From: Roger Spencer <Roger.Spencer@arun.gov.uk>
Sent: 29 March 2022 15:44
To: Michael Eastham <Michael.Eastham@arun.gov.uk>
Cc: Sarah Burrow <Sarah.Burrow@arun.gov.uk>
Subject: RE: LU/417/21/OUT - 71 units at Toddington

This Outline Application builds upon the approved Outline Application LU/47/11 and subsequent approved Discharge of Condition Application LU/17/19/DOC.

Drawing No. **D1970-PL301**

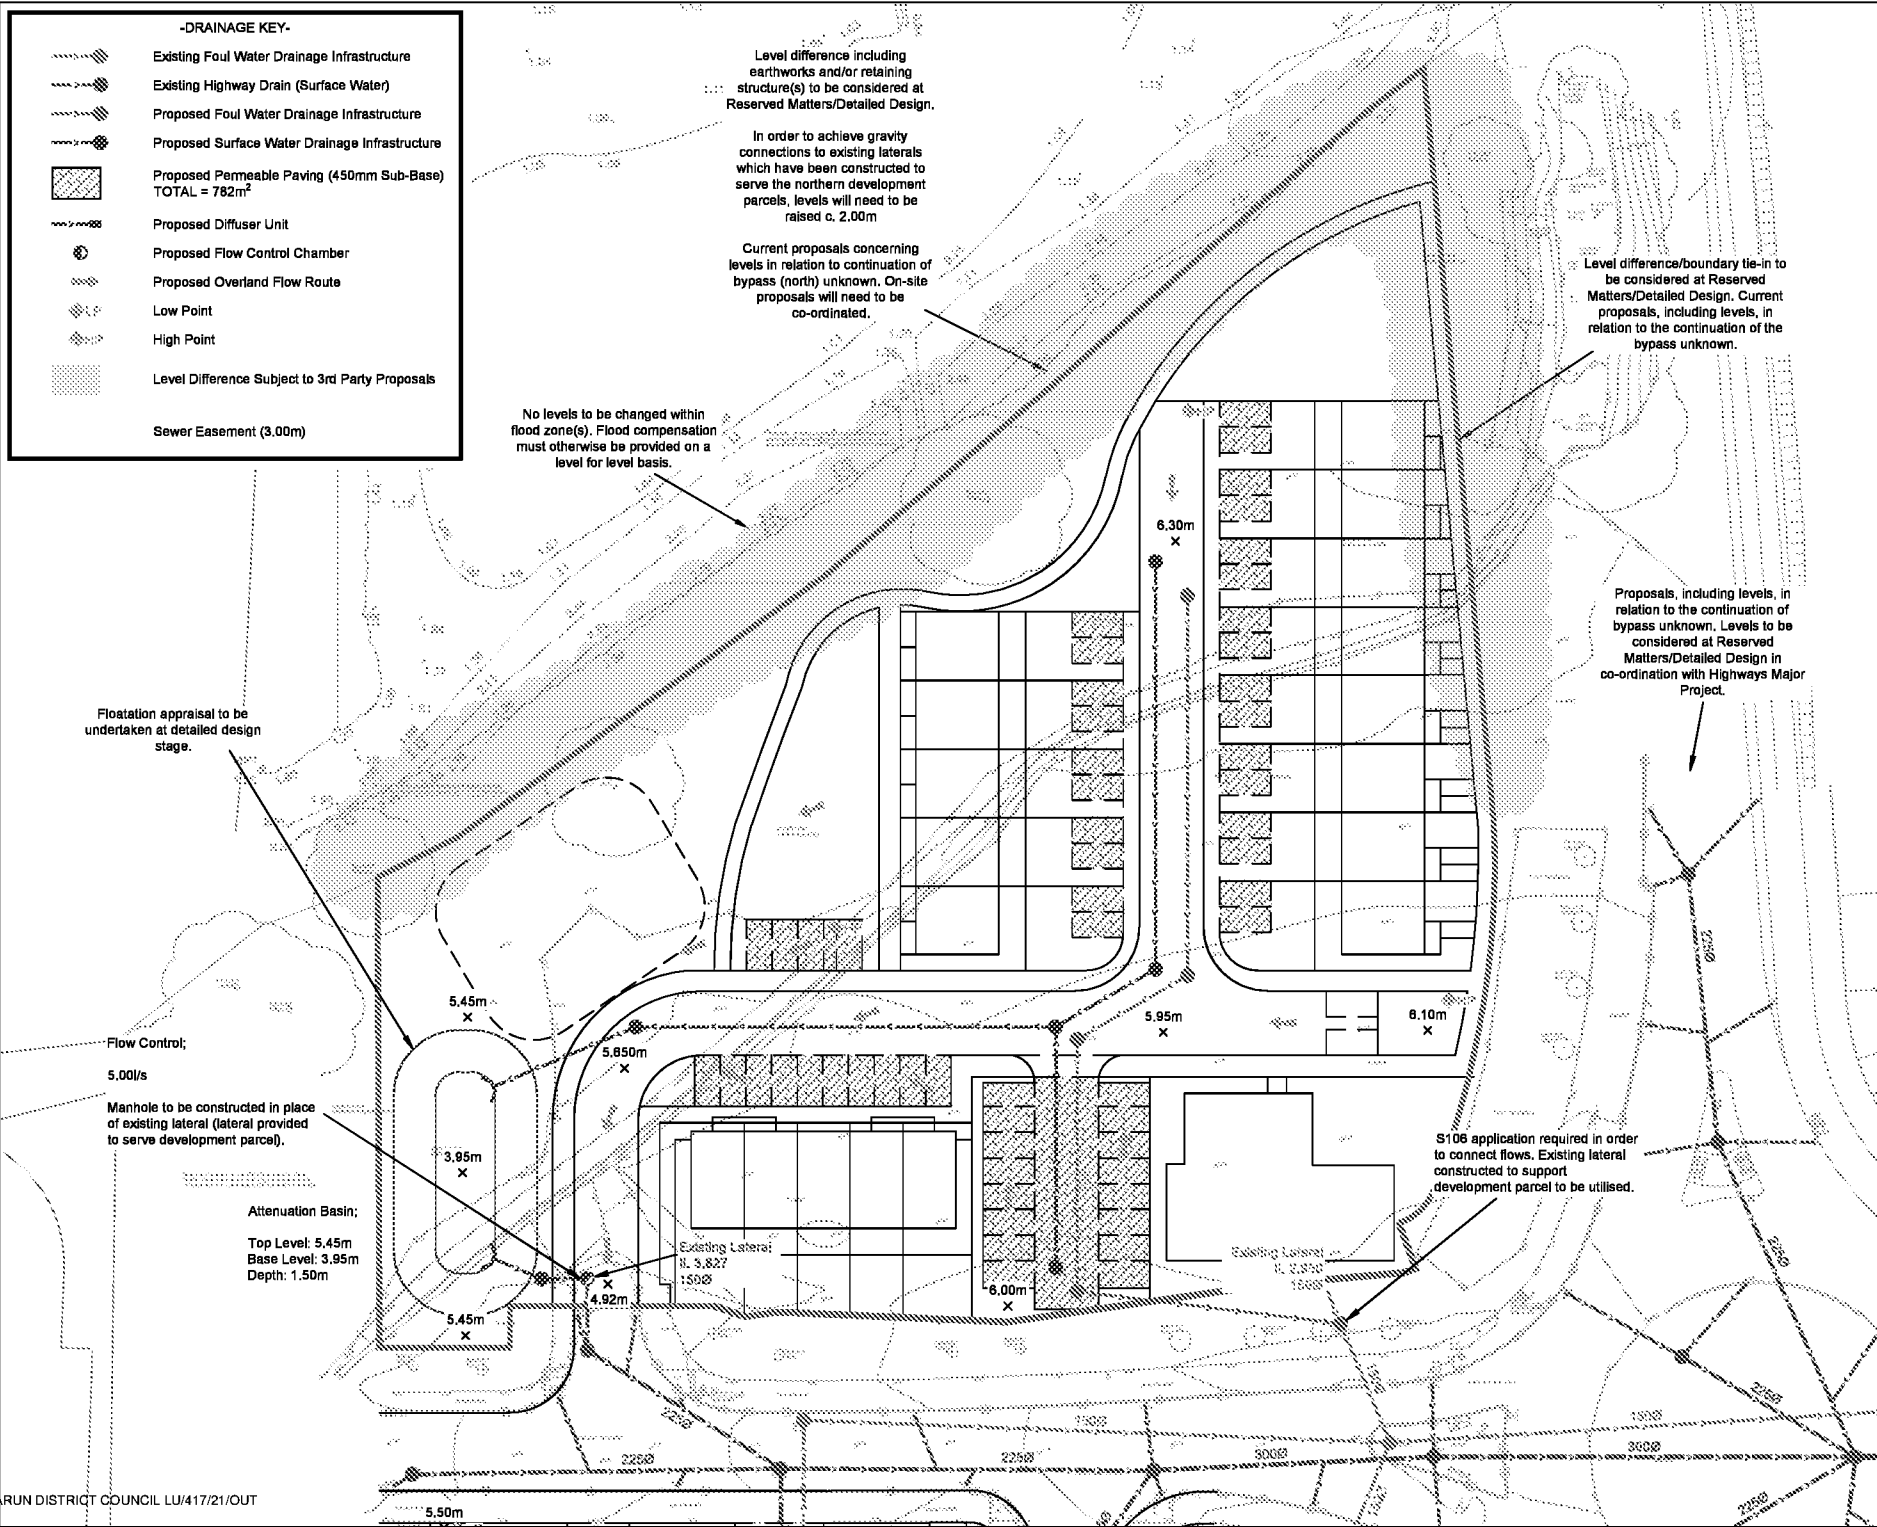
It is noted that there may be a conflict with an existing foul sewer easement running north/south in Site A and one of the Site A units that faces north. There would also seem to be a 225mm dia. Surface Water sewer, serving the swale behind 65-85 Hinchcliff Drive, which flows north-east to the manhole in the entrance to Site A
